**SSD 6626 - SICEEP Darling Square - Mixed Use Residential  
Building within North-East Plot**

**21 November 2014**

## SSD 6626 Submission

Concept proposal
parameter plan shadows
for N + SE plots

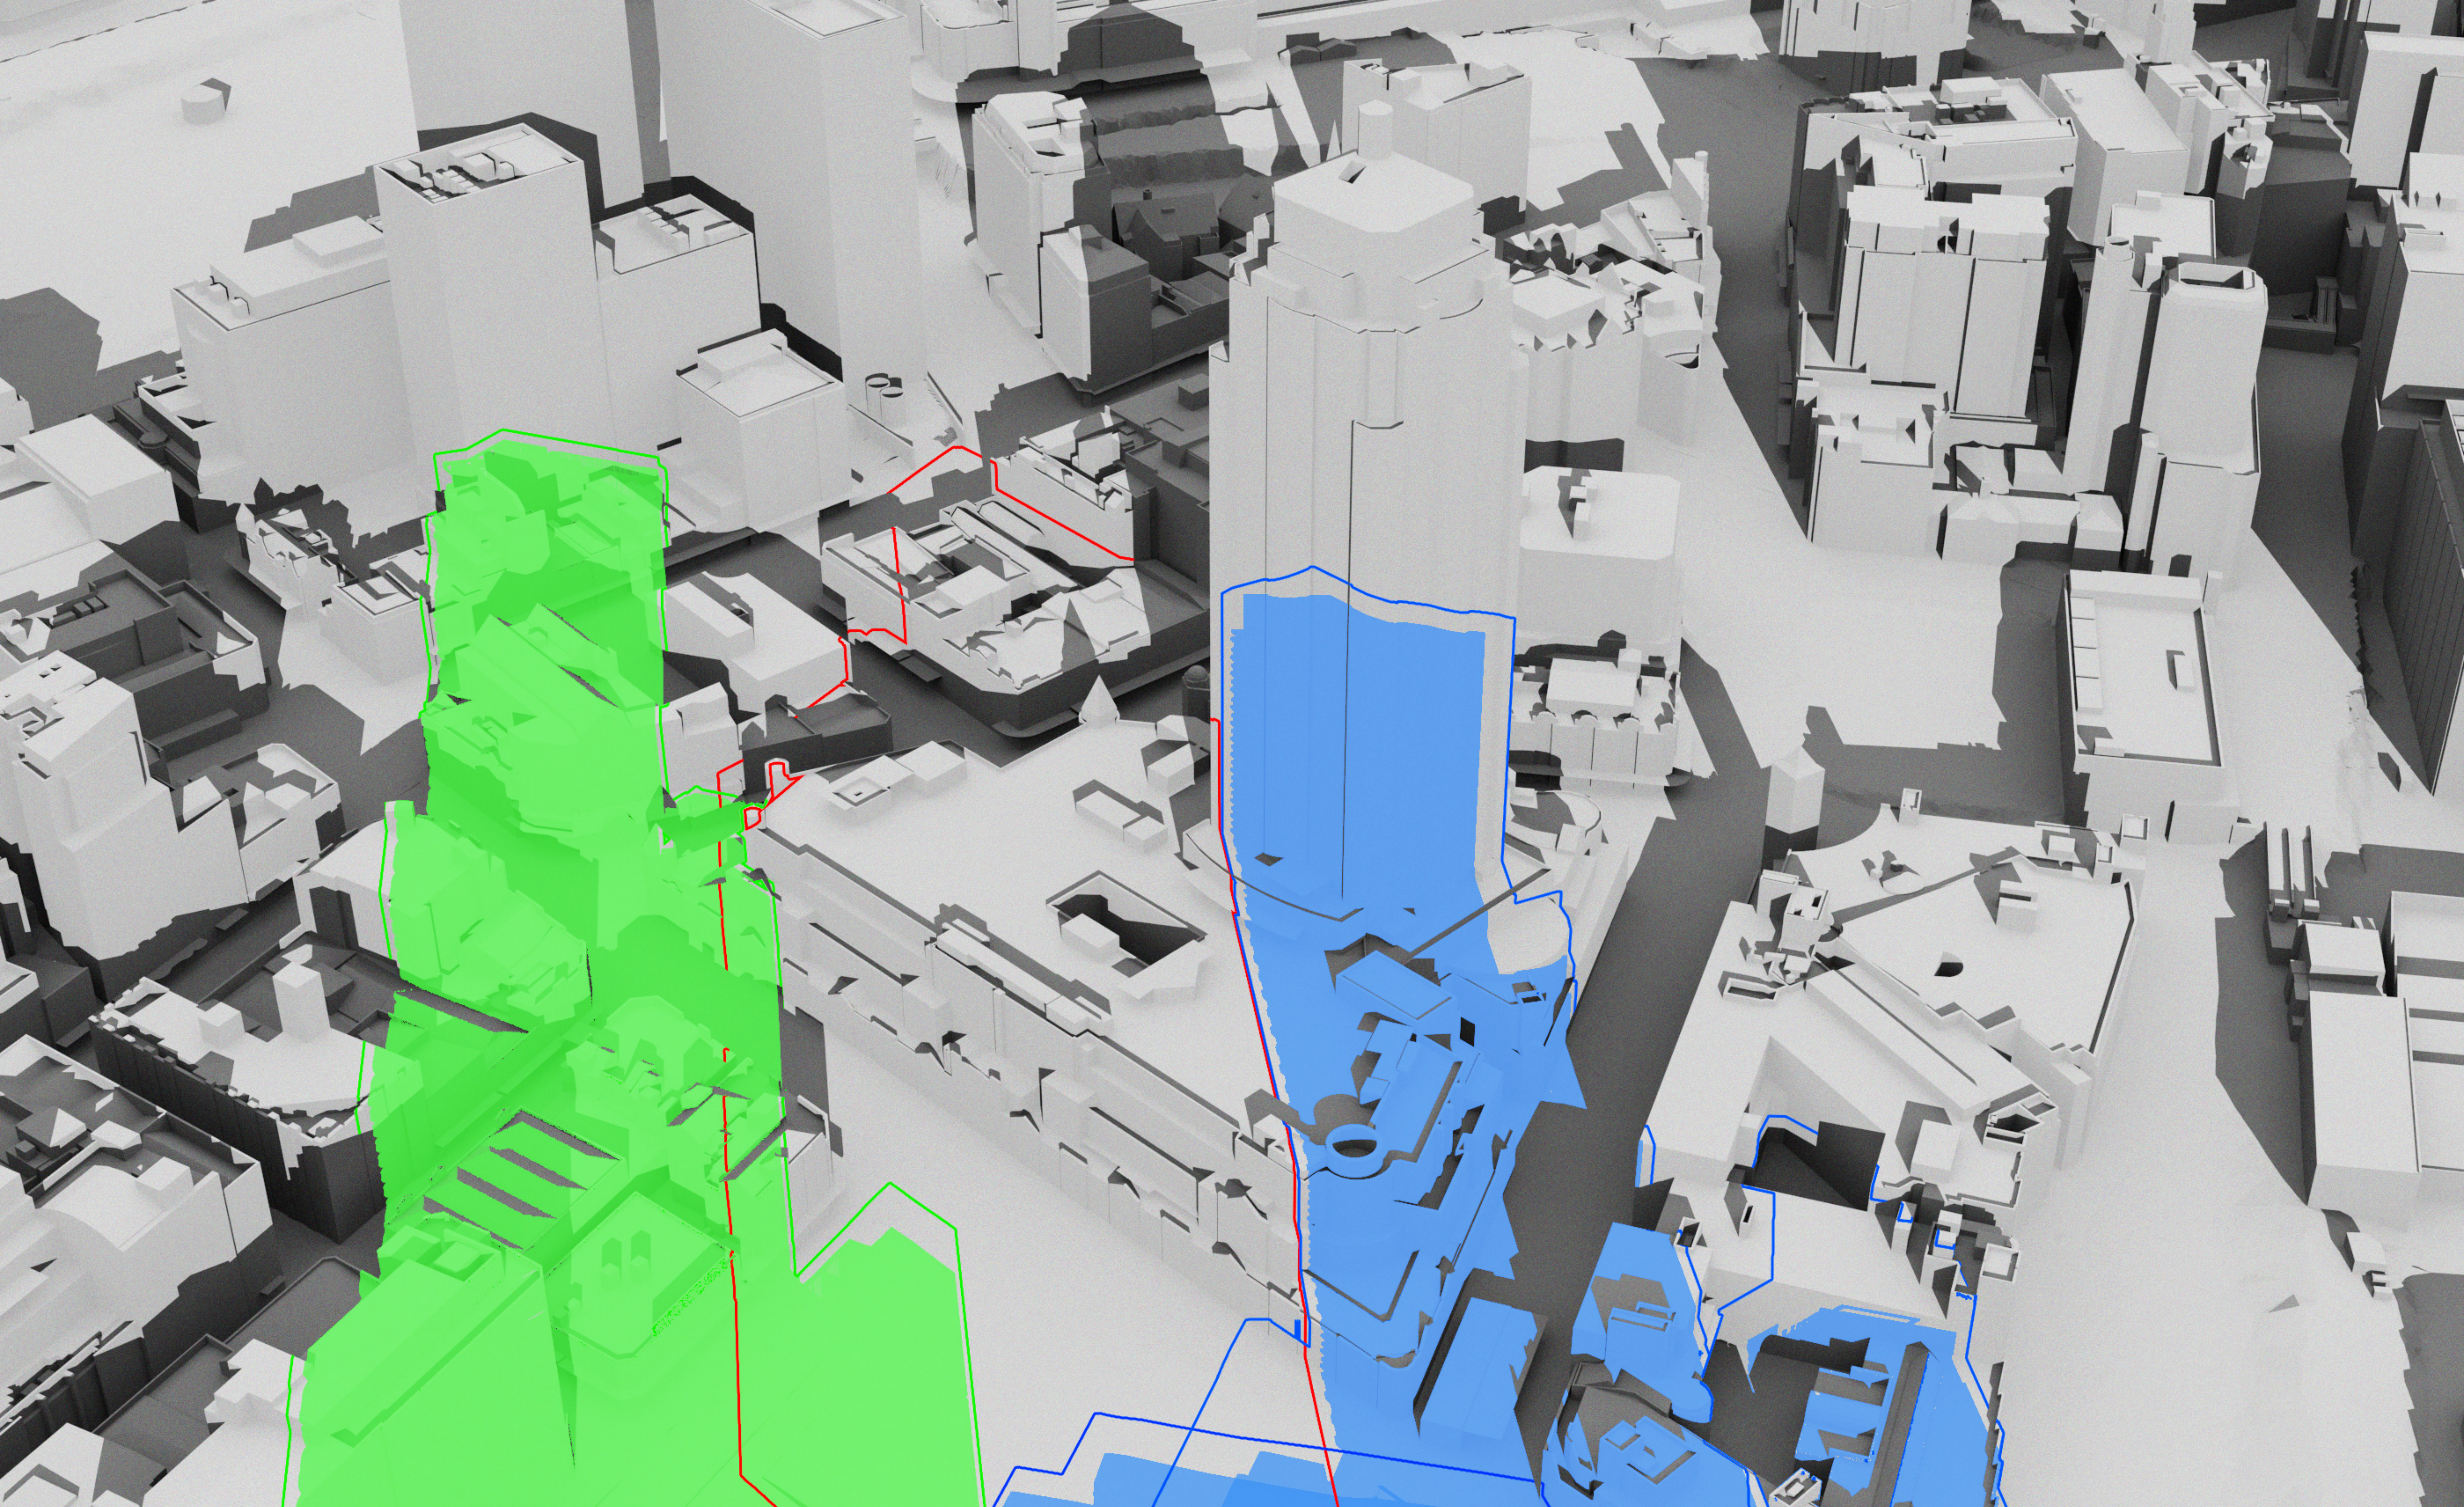
## **Excessive overshadowing of public open space - the new square - "Haymarket Square"**

We agree with the City of Sydney's view that "excessive morning shadows are cast into the outdoor and café areas in the new square by new surrounding building edges. In order to improve morning sun access to the square in winter, it is recommended that the building heights lining the new square be reduced and the floor area relocated to the surrounding streets podium edges..." Source: City of Sydney, SSD 5878 (SICEEP) The Haymarket submission, page 34.
